Item No. **Report of the Head of Development Management and Building Control**

Address: 58A STATION ROAD HAYES

Development: Erection of 2 additional storeys to create a flat at first and second floors above ground floor commercial unit.

LBH Ref Nos: 69395/APP/2025/797

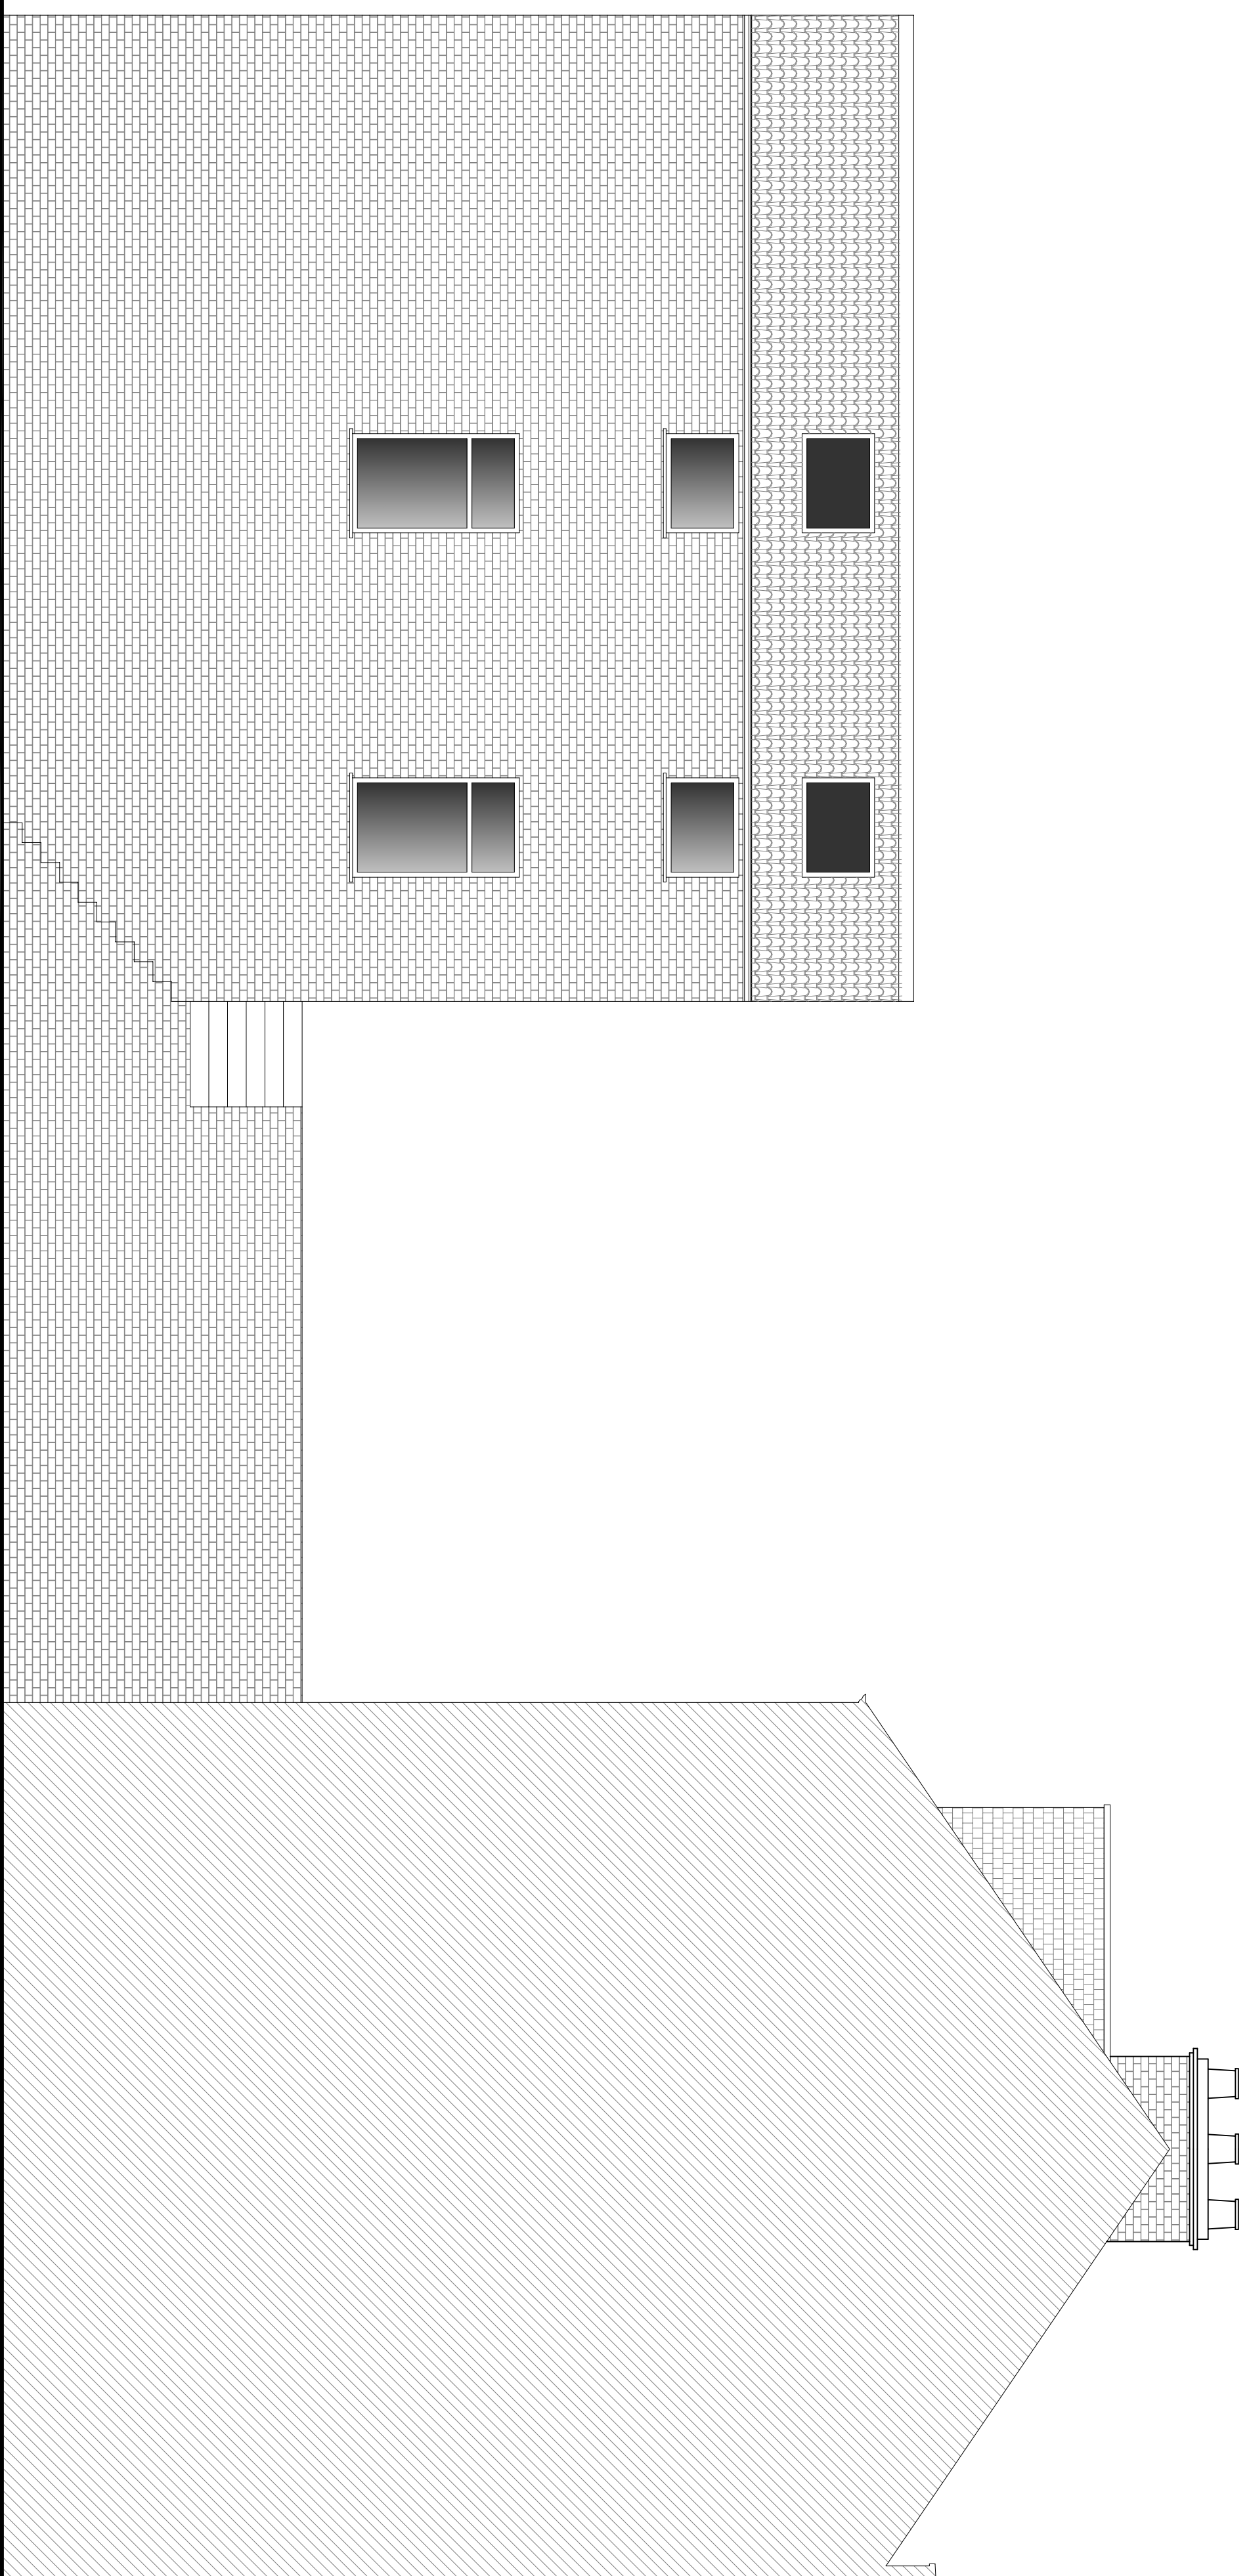
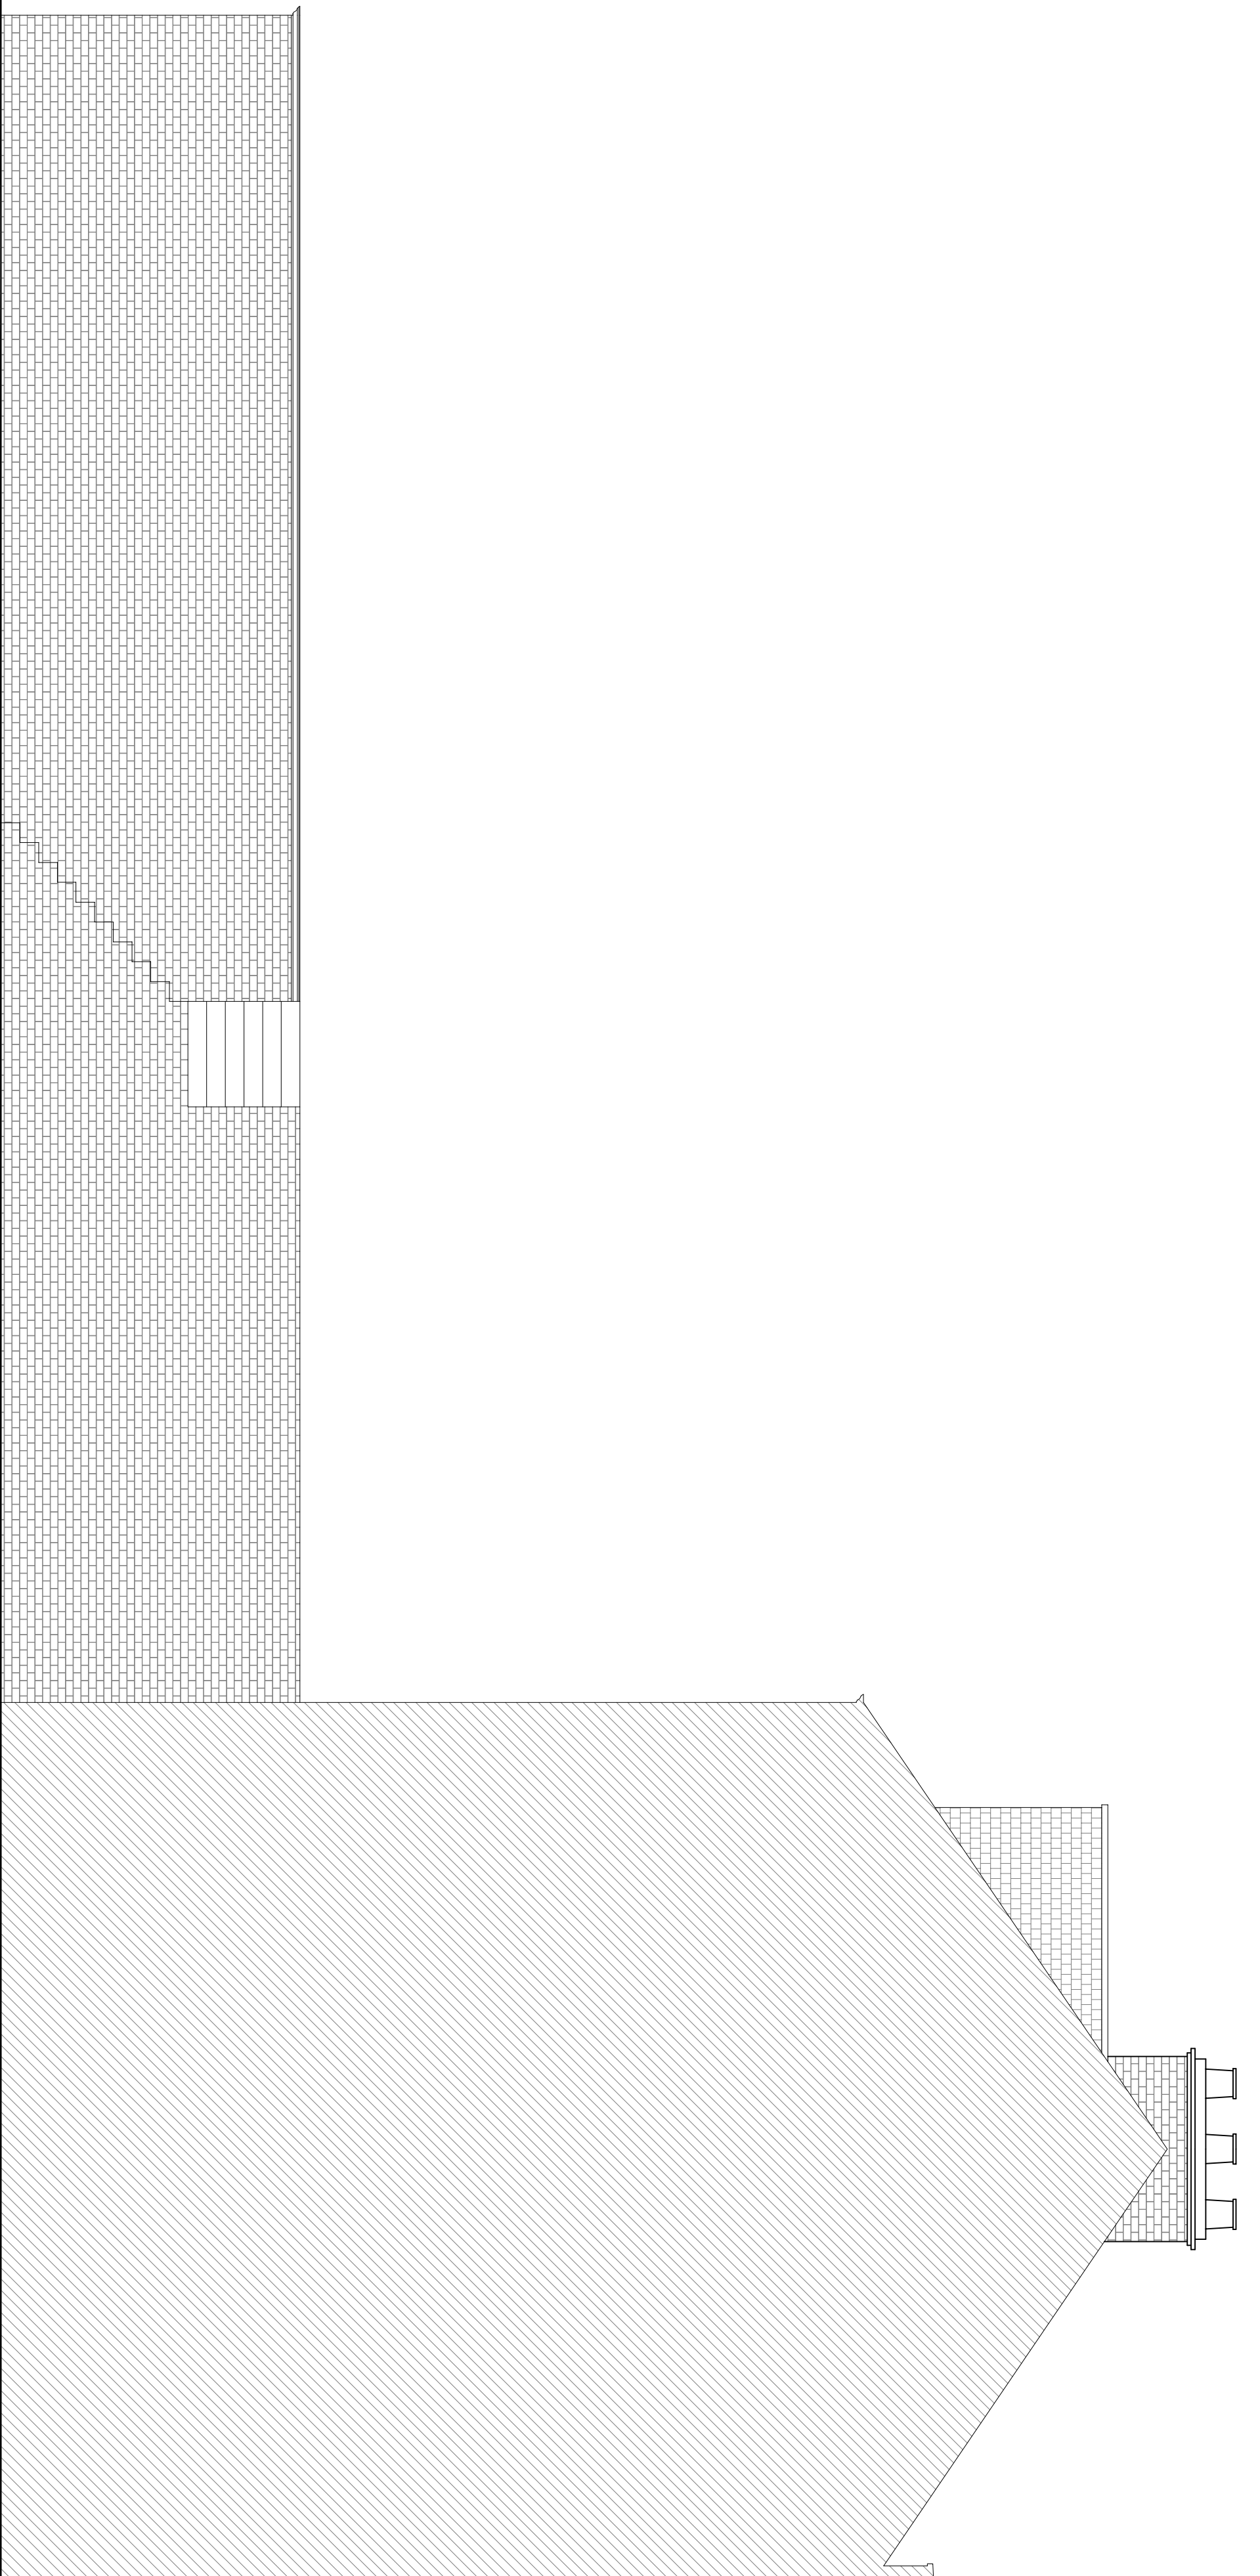
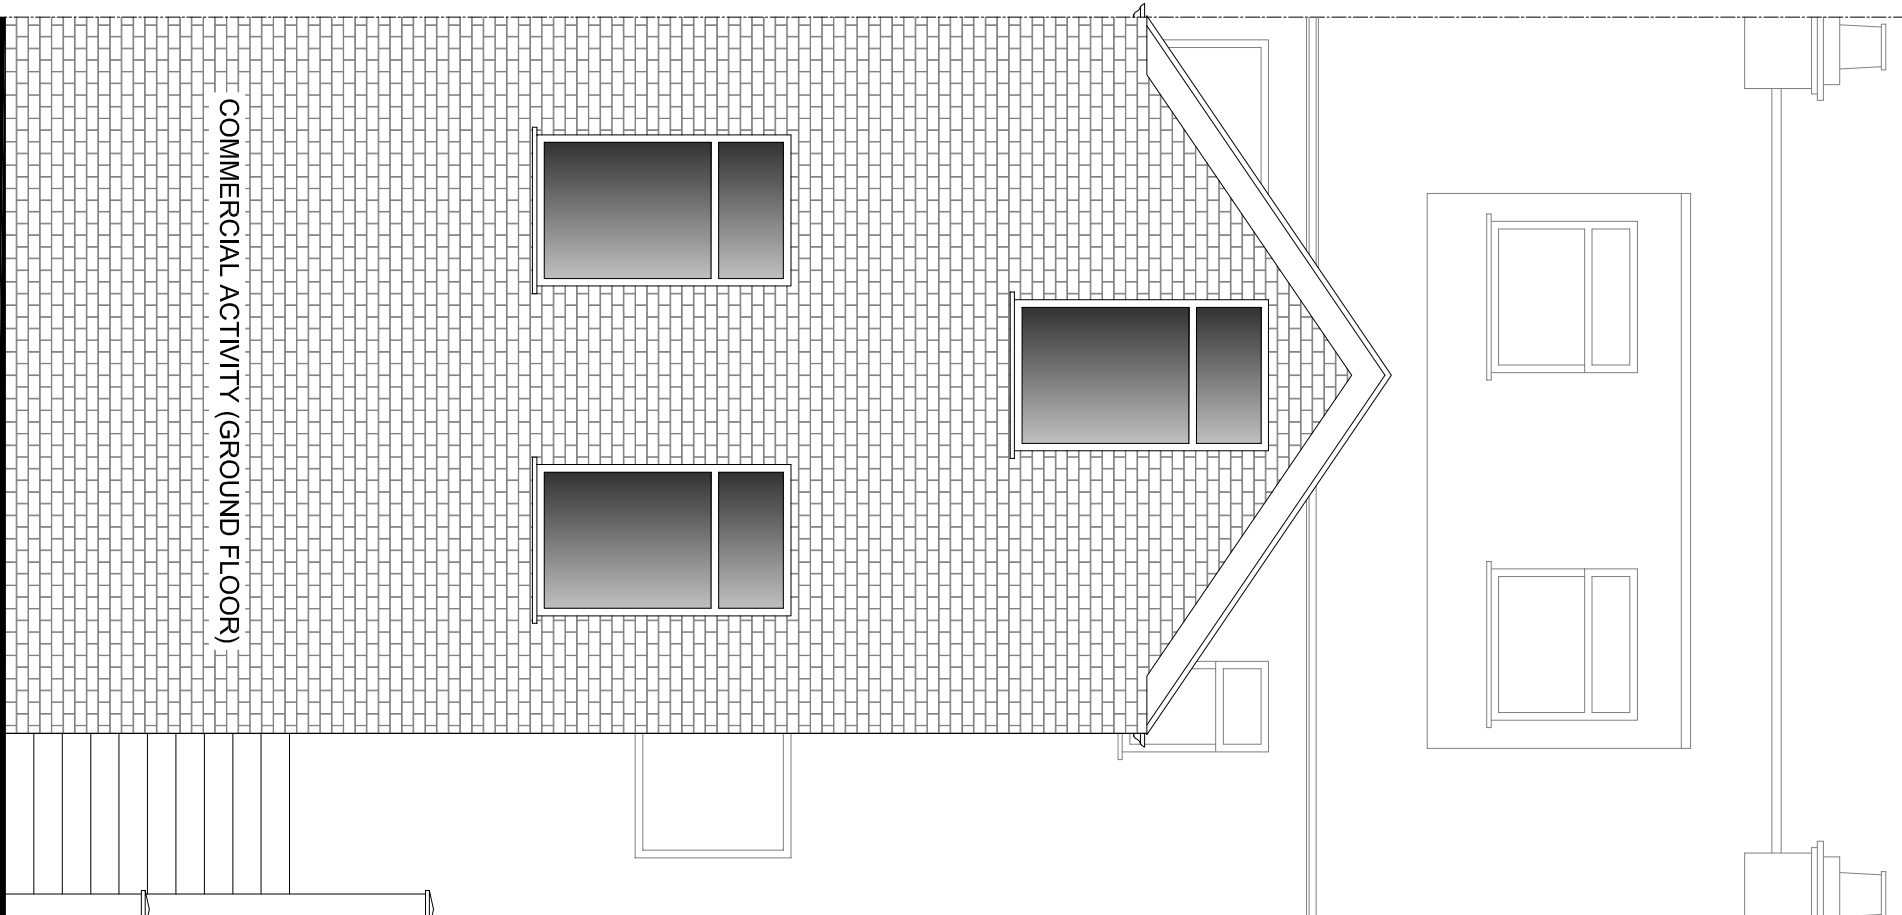
Relative to the previously refused scheme, the floor plans show the proposed second floor has been set back from the front elevation by 1.15m and has been redesigned with a flat roof. The proposed elevations show however both the first and second floor being set back, therefore the plans do not tally with the elevations.
